From: Jeff Watson
Sent: Monday, June 10, 2013 2:28 PM
To: rg98926@yahoo.com; 'patmcf@fairpoint.net'
Cc: Paul Jewell
Subject: BL-13-00007 Grossman
Attachments: BL-13-00007 Grossman Master File.pdf

[BL-13-00007 Grossman](#)

BOUNDARY LINE ADJUSTMENT SURVEY		
PREPARED FOR		
ROD GROSSMAN		
A PORTION OF THE SW 1/4 OF THE NW 1/4 AND THE NW 1/4 OF THE SW 1/4, OF SECTION 25, TOWNSHIP 19 NORTH, RANGE 17 EAST, W.M., KITITITAS COUNTY, WASHINGTON		
DWN BY	DATE	JOB NO.
DLP	6/2013	13014
CHKD BY	SCALE	SHEET
GW	1" = 100'	1 OF 2

Attention: Jeff Watson, Planner
Subject: BL-13-00007 – Grossman – SR 97, milepost 142.60 right

BL-13-00007

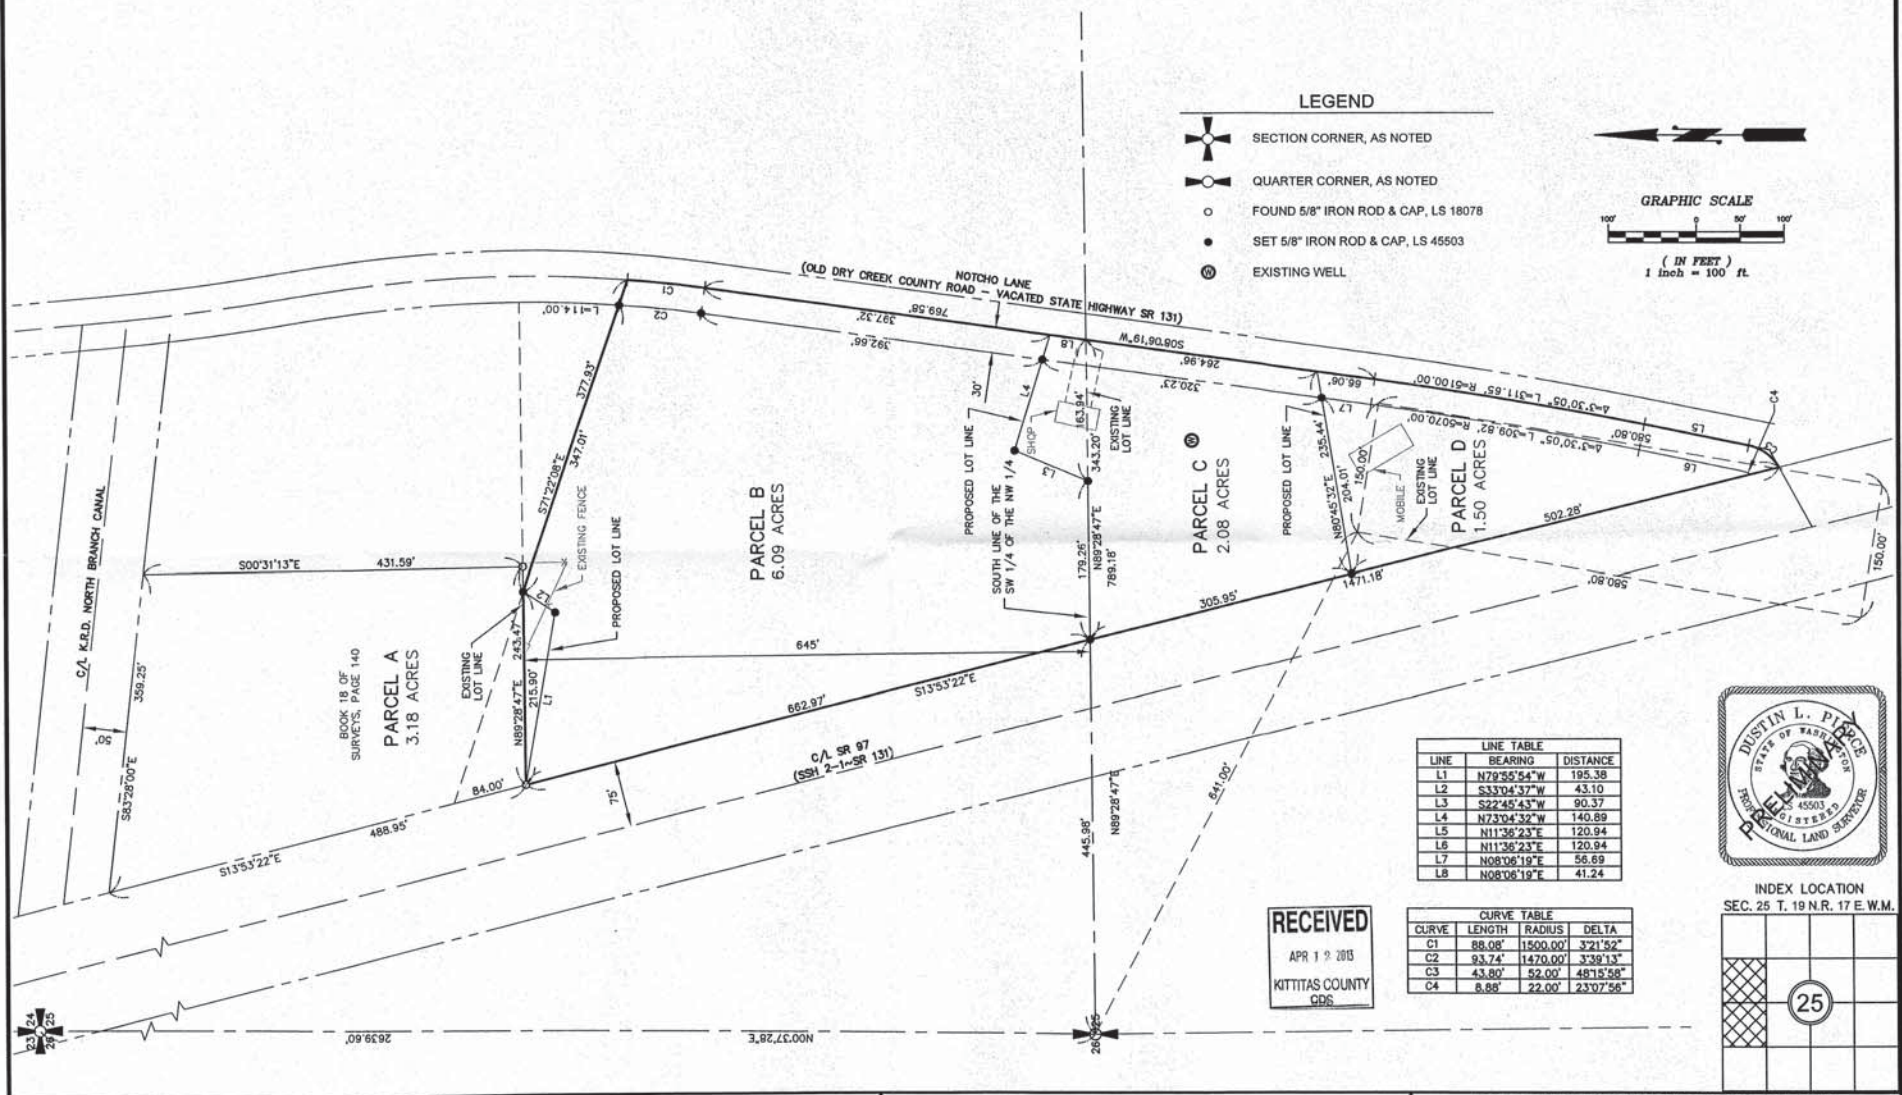
- The property is adjacent to U.S. Highway 97 (US 97), a Class 1 managed access facility with a posted speed limit of 65 miles per hour. Class 1 highways favor mobility over access to adjacent properties. WAC 468-52-040 and others stipulate, “if access is available via the general street system, primary access shall be provided from the general street system rather than from the state highway.” No more than one access is allowed for contiguous parcels under the same ownership.

- The former State Route 131 (SR 131) runs along the east side of the property. This portion of SR 131 was relinquished to the County. The County then vacated this right-of-way without providing an access easement to abutting properties. Notcho Lane remains a public at-grade intersection within WSDOT right-of-way.

- According to our records, parcels “B”, “C”, and “D” are under the same ownership; this is the only property owner with the legal right to access US 97 via Notcho Lane. Parcel #19-17-25020-0011, though unrelated to this proposal, has no legal means of access to the highway. Without an established access easement, the right to use Notcho Lane will remain solely with the owner of parcel “D”.

In summary, we require an access easement be reserved from Notcho Lane to serve parcels “A”, “B”, “C”, and “D” of this boundary line adjustment as well as parcel #19-17-25020-0011. No new approaches to US 97 will be allowed.

Christina/Jeff-there has been an interpretation that the easement provided to Probasco under AF426164 for the access easement on Notcho lane is a “non-exclusive” easement. As such, the concerns we raised in our comment letter dated May 21, 2013, have been addressed. WSDOT does not require anything further regarding this BLA.
